Retention of 1.8m high trellis fence to front boundary.
2 Sea Lane Gardens Ferring

Thank you for your internet representation made on 2nd July 2018 which has been recorded as '**an objection**' with the comments as follows:

Elevation to Sea Lane

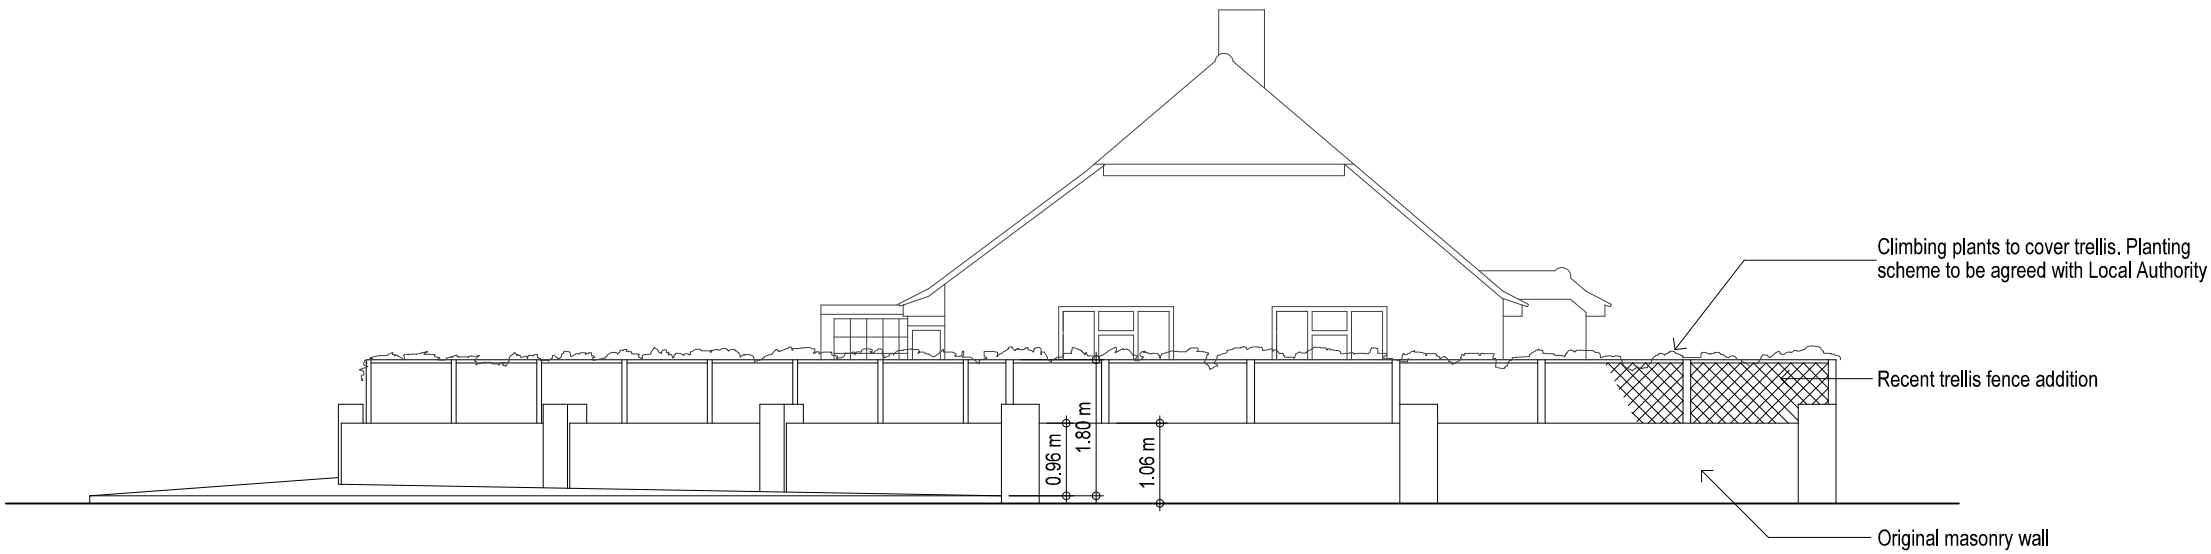
The fence is over 1 meter high

The fence is not in keeping with the surrounding properties. This part of Sea Lane has a number of old cottages , including a listed cottage which are often photographed and used on postcards and charity Christmas cards. None of the cottages have fences adjoining the road. This fence detracts from the beauty of the surrounding ares

Finally the hight of the fence obstructs the view on a very dangerous corner.
